Sent: 15 October 2013 07:13
To: Planning
Subject: objections 4 wilkins green lane
Attachments: 4 Wilkins Green Lane development-repeat objections.docx

Planning reference **S6/2013/1469/FP**

TITLE Proposed Ground & First Floor Plan		
PROJECT NAME Oak Cottage, 4 Wilkins Green Lane, Hatfield, AL10 9RT		
DRAWN BY E.B	DATE SEPT 2013	
SCALE 1:100 @ A1	CHECKED	
DRAWING NO. EL/2012/05	REV. NO. E

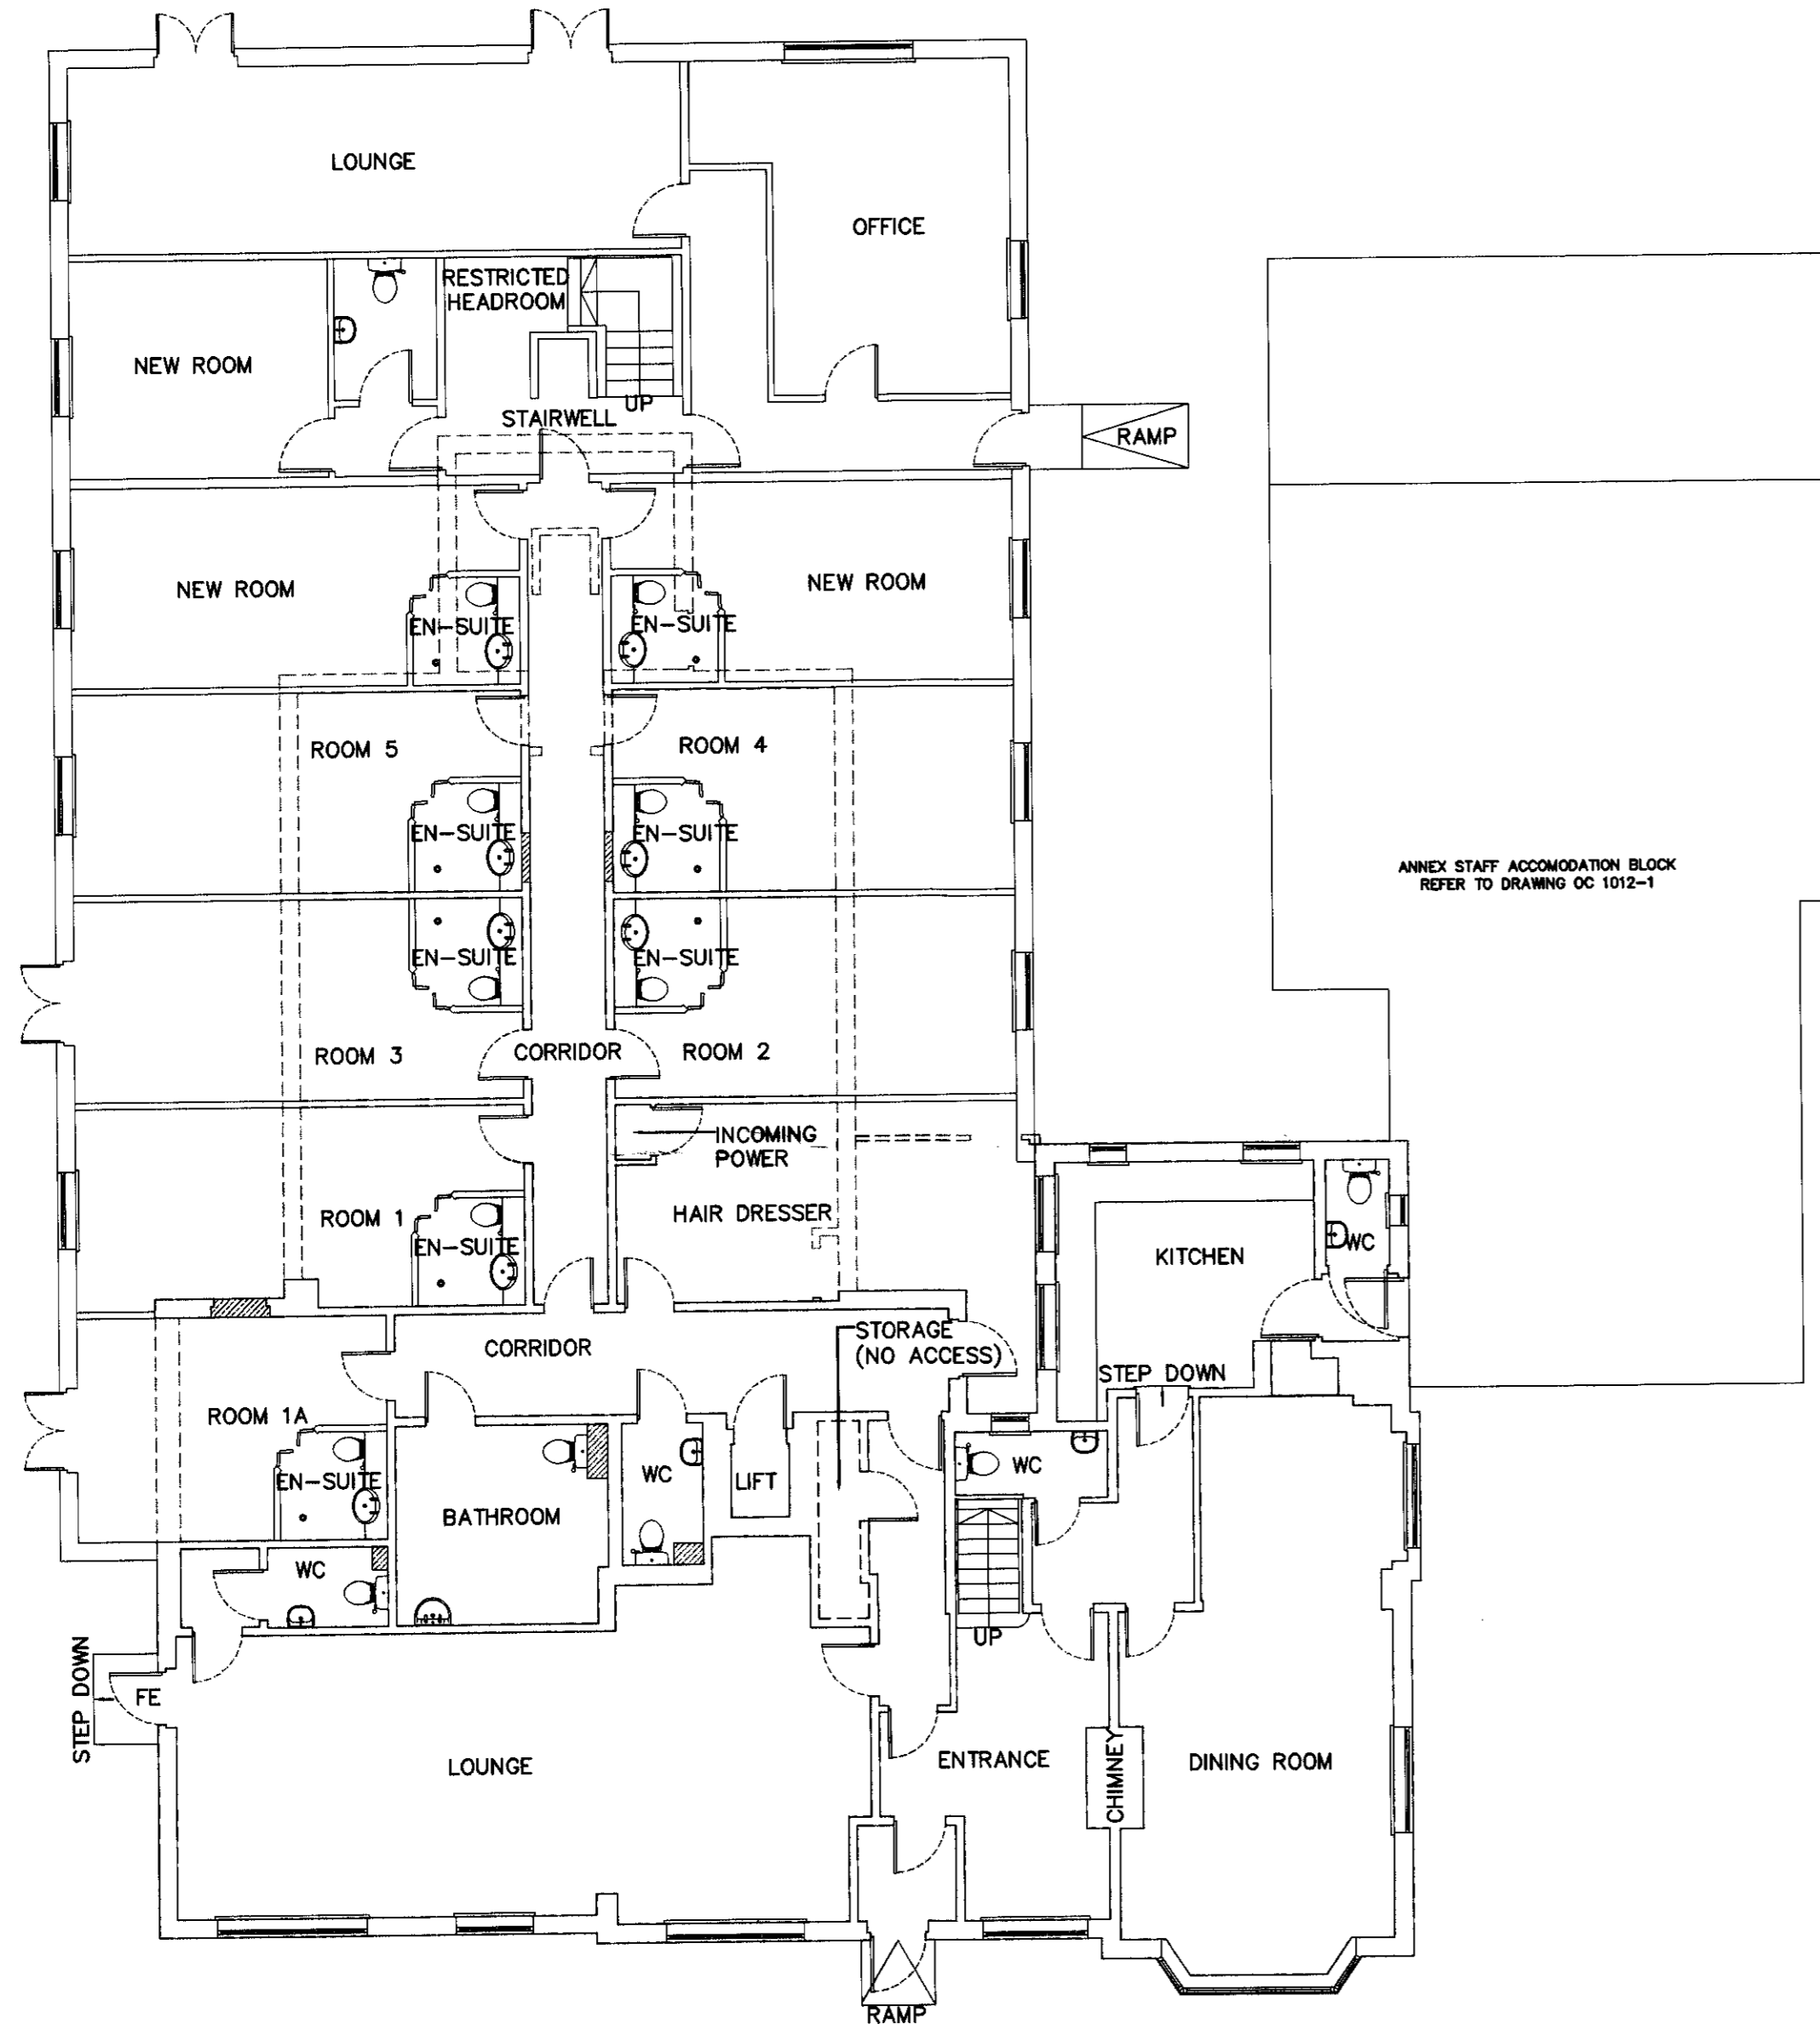
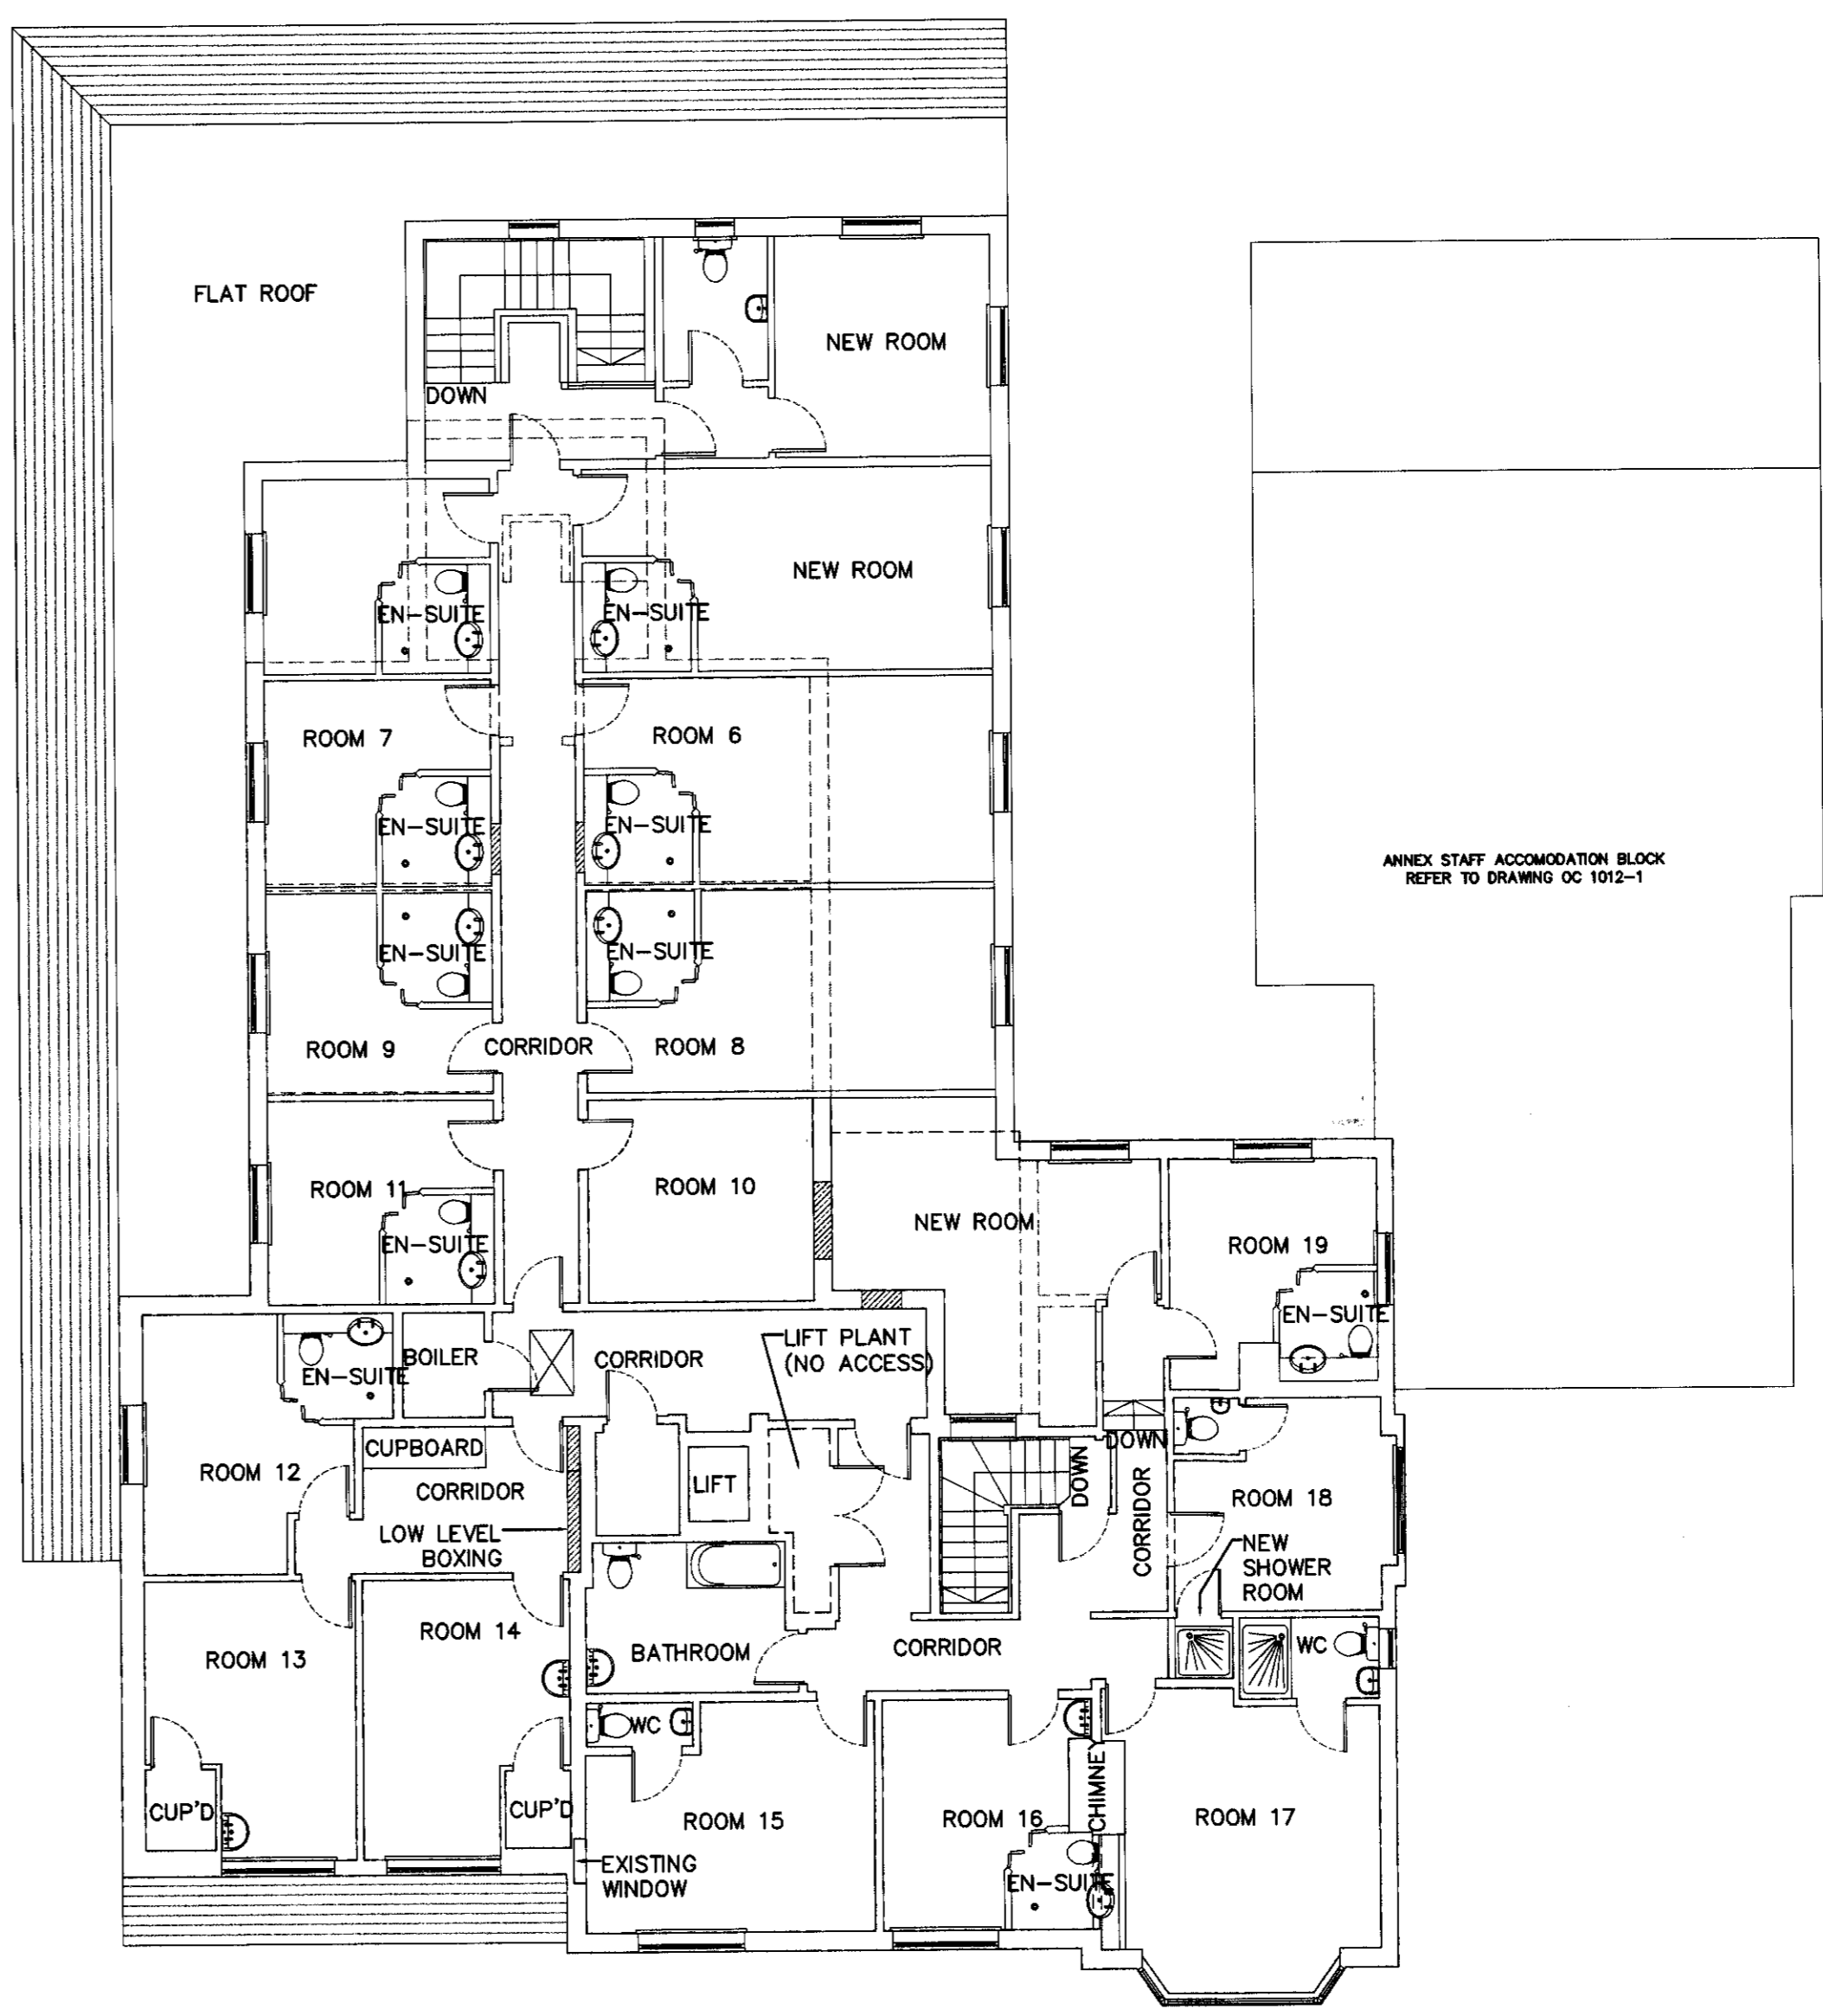
Firstly we are not satisfied with the size of this extension. The covering letter refers to an approval in 2007 (S6/2007/1947/FP which was a much smaller scale extension, tacked on the middle of the building. The current proposal is for a much larger extension than proposed in 2007 and would be totally inappropriate overdevelopment for this site.

Secondly, of major concern is the intrusion and invasion of privacy. This application has side additional windows of clear glass well beyond the current building lines looking into the gardens of neighbouring properties This are unacceptable. In addition as there must be some confusion as it states that *"the elevation to number 6 is shielded by a high conifer hedge"* but the site adjoins to our property number 5! It is so close that not only may be destroy the hedge but we will also be cutting the conifer hedge to reduce the height and then the extension will be in full view. We stated previously the bare minimum requirement would be that the windows *"shall be glazed with obscured glass and shall be fixed so as to be incapable of being opened below a height of 1.8 metres above floor level, and shall be retained in that form thereafter."*
